Recommendation Report for Planning Permission for Works or Extension to a Dwelling

REF NO: BR/180/25/HH

LOCATION: 23 Pinewood Gardens
Bognor Regis
PO21 2XB

PROPOSAL: Two storey side extension following demolition of existing garage, alterations to fenestration and vehicular crossover.

Drawing Title: Tree Protection Plan 1:100 @ A2

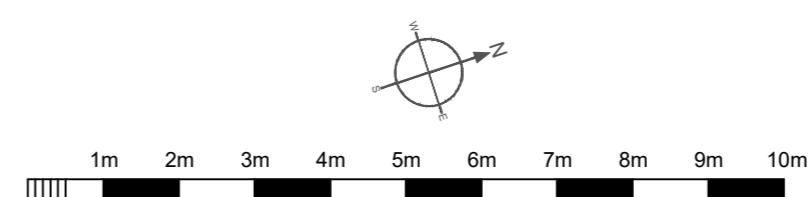
There are two protected trees within the garden which are located close to the development and are subject to Tree Preservation Orders. Subject to suitable protective fencing as outlined in the Arboricultural Impact Assessment, the trees will not be adversely affected as a result of the proposal. As such, a condition is attached to this consent to require evidence by way of written report(s) with attached photographs demonstrating that all protective fencing and ground protection has been inspected to verify it is 'Fit for Purpose' as required under British Standard 5837:2012 to be submitted to and approved in writing by the Local Authority prior to the commencement of works. Such protective measures must be erected and positioned exactly as shown on the Tree Protection Plan. Subject to this condition, the

3 Prior to the commencement of the development hereby permitted, including prior to any machinery being introduced to the site or demolition work or construction work or alterations to existing ground levels takes place, the Arboricultural Expert representing the site owner(s) must provide the local planning authority with evidence by way of written report(s) with attached photographs demonstrating that all protective fencing and ground protection has been inspected to verify it is 'Fit for Purpose' as required under British Standard 5837:2012 and been erected and positioned exactly as shown on the Tree Protection Plan.

PROPOSED ELEVATIONS

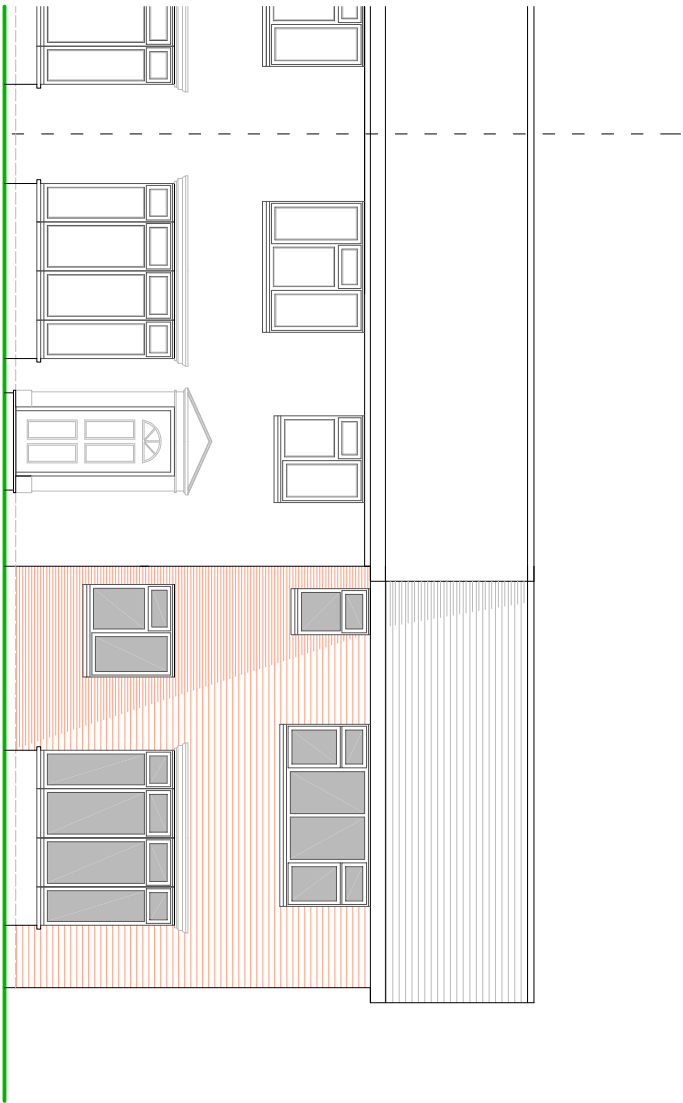
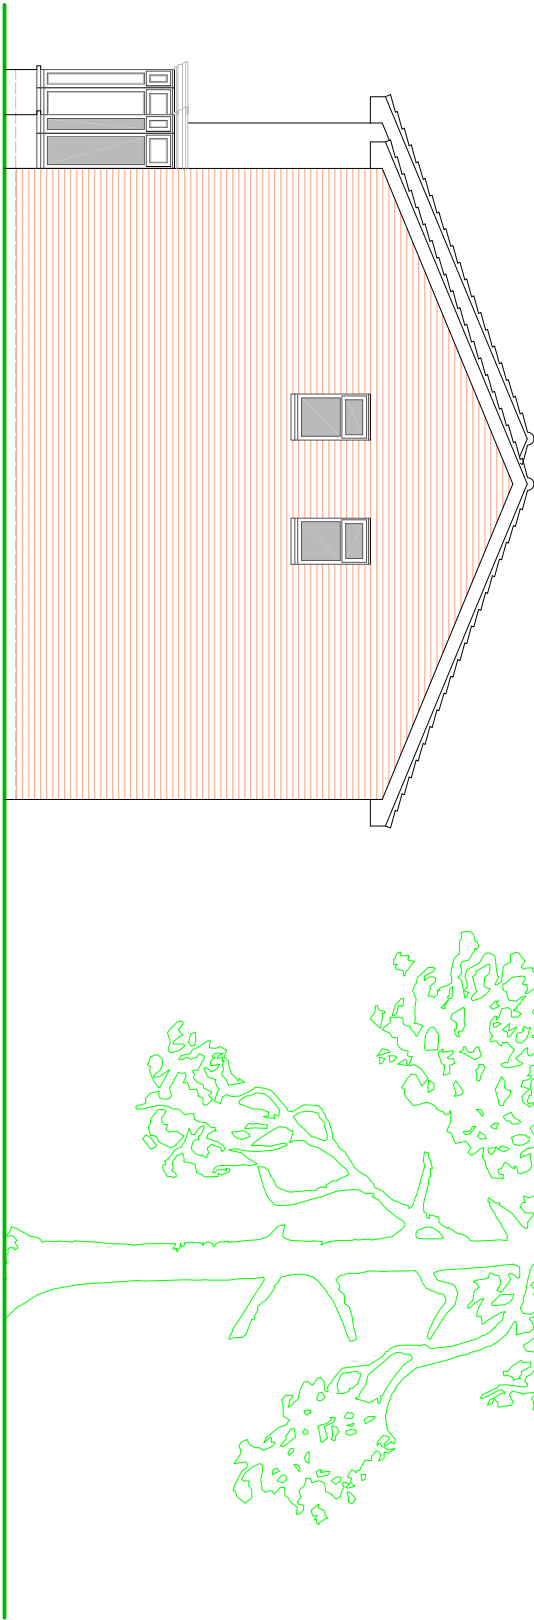
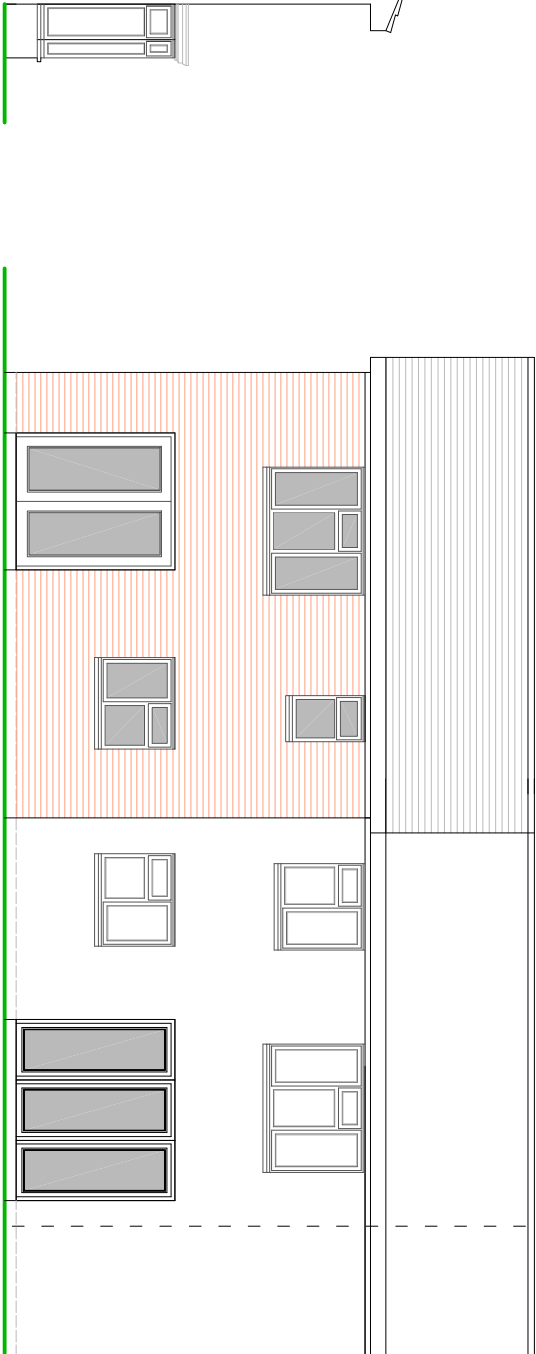
The proposed two storey side extension would adjoin the eastern flank elevation of the dwelling and would measure 5.9m in width, 8.4m in depth and would have an eaves height of 4.8m, matching the existing eaves height of the host dwelling, and a maximum height of 7m, adjoining the existing ridge height. Section M.01 of the Arun Design Guide (ADG) specifies that side extensions should be set back from the front elevation and down from the ridgeline by a minimum of 0.5m. The height of the proposed extension would be equal to the ridge height of the existing dwelling, whilst the extension would be set back from the principal elevation by 0.6m, thus the extension would only partially accord with this section of the ADG. According to the ADG, side extensions should respond to building design in terms of roof pitch and use complementary and integrated materials and elevational design. The proposed extension would not appear as a subservient addition to the host dwelling, however it would integrate well with the existing dwelling as the extension would retain the character of the property by featuring matching materials to the existing dwelling and the extension would have a pitched roof form, reflecting the existing dwelling. As such, the extension would not appear out of place within its context and the proposed two storey side extension would not result in harm to the character of the host dwelling or street scene.

The proposed fenestration within the front elevation would have an outlook of the application site frontage, and would not result in any overlooking. The side elevation would contain two windows at first floor level, facing Hawthorn Road. Given the presence of a medical centre to the east, and the spacing maintained between the extension and the medical centre, the proposed side fenestration would not result in any overlooking. To the rear, a window and a door are proposed at ground floor level, and two windows are proposed at first floor would not give rise to views significantly different to those currently achieved from the existing rear fenestration. As such, the proposed extension would not result in harm by way of overlooking.

One of the existing rear windows would be replaced with a set of patio doors which would give rise to views of the rear garden and would not be significantly different to those achieved from the existing rear windows. As such, the proposed amendment to fenestration would not result in additional overlooking.

PROPOSED STREET ELEVATION

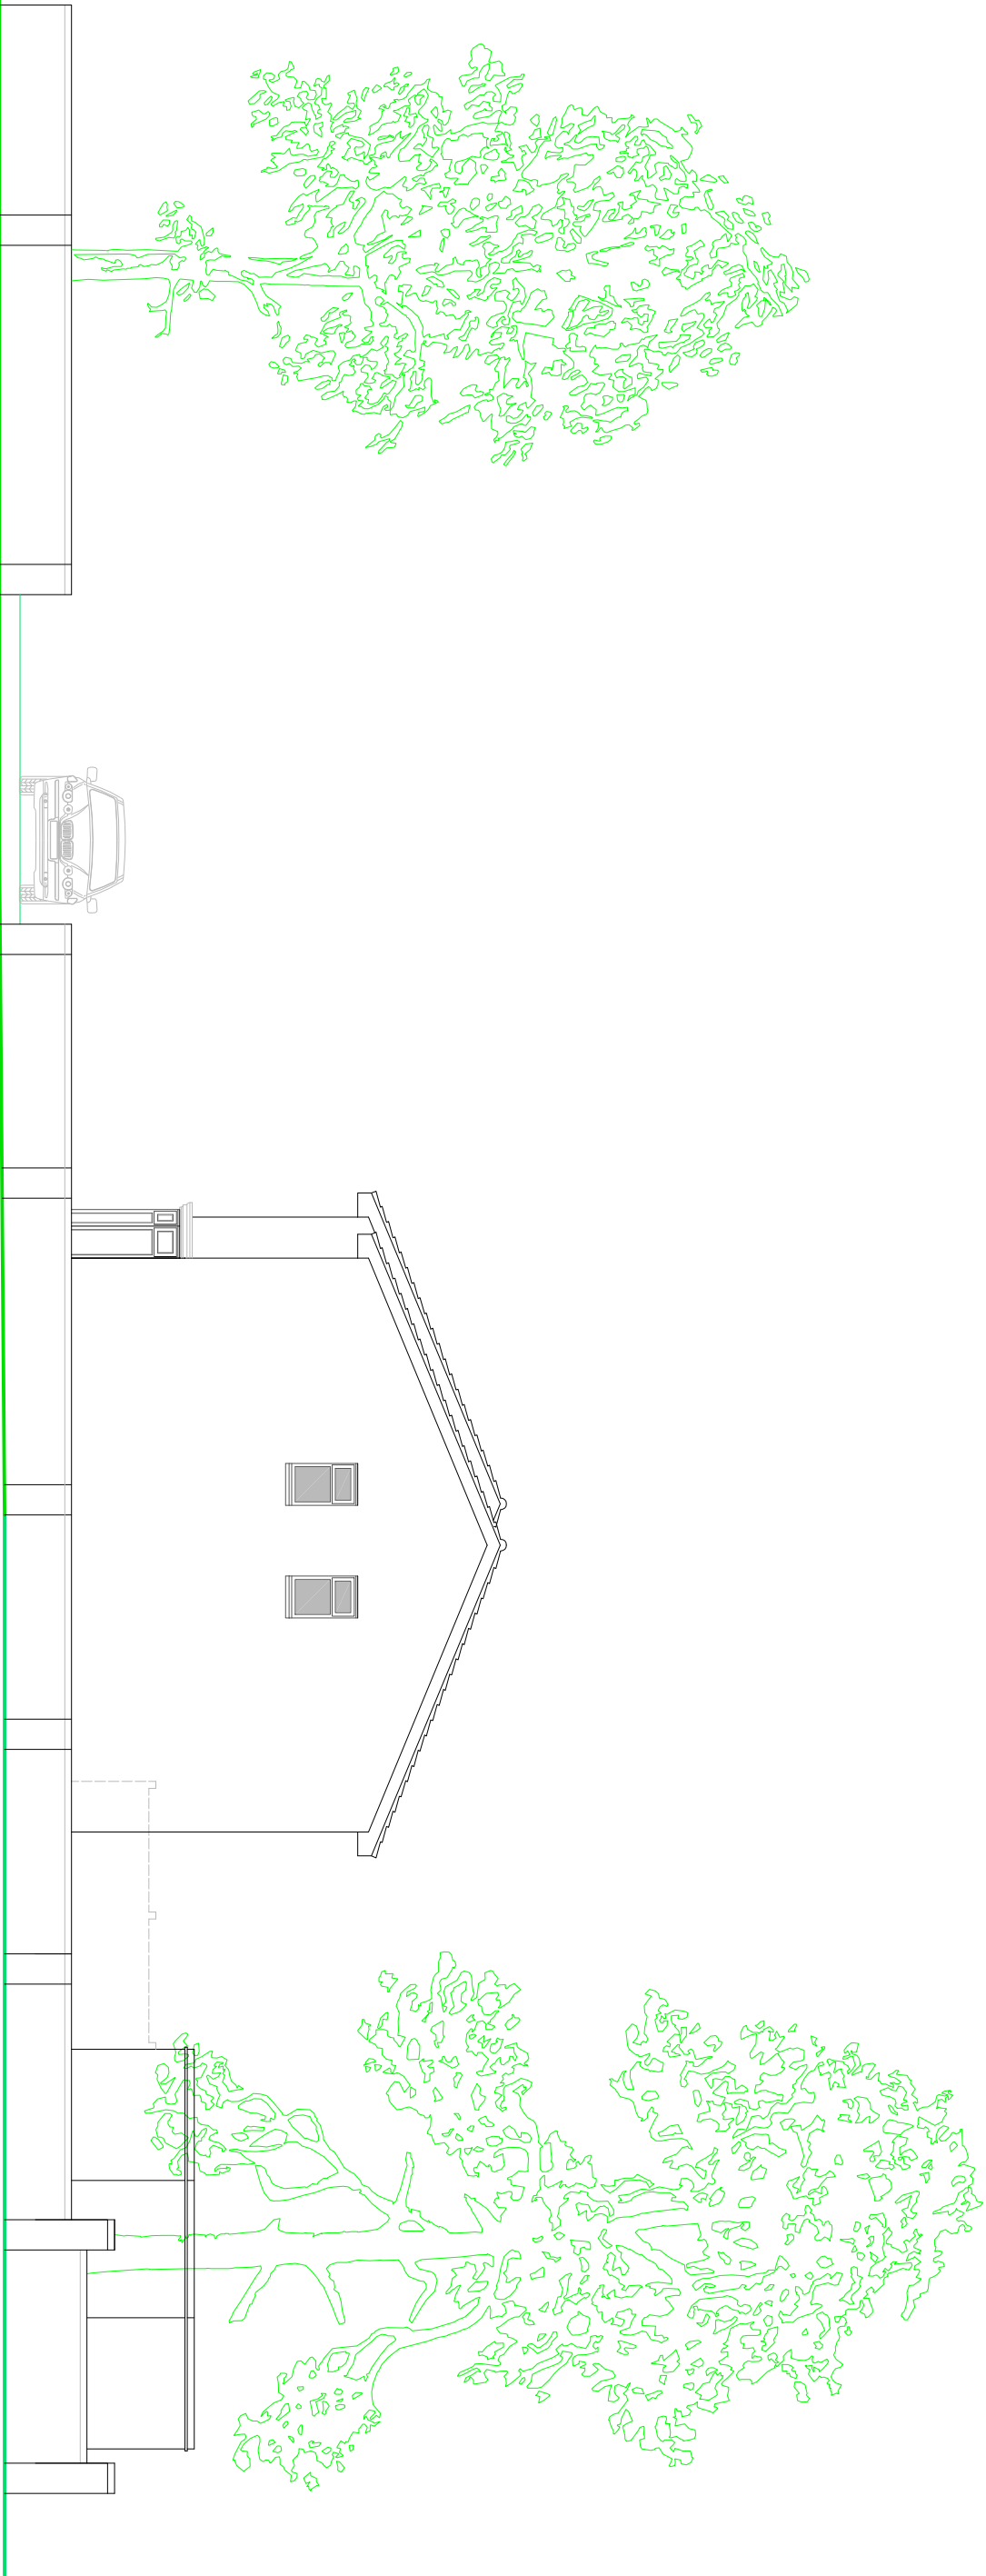
The site is an end of terrace, two storey dwelling located along Pinewood Gardens, at the junction with Hawthorn Road. This application seeks planning permission for the construction of a two-storey side extension, amendments to fenestration and a new vehicle crossover, as well as the removal of the existing garage. The proposed materials and finishes would match the existing dwelling. The proposed two storey side extension would be visible from the street scene.
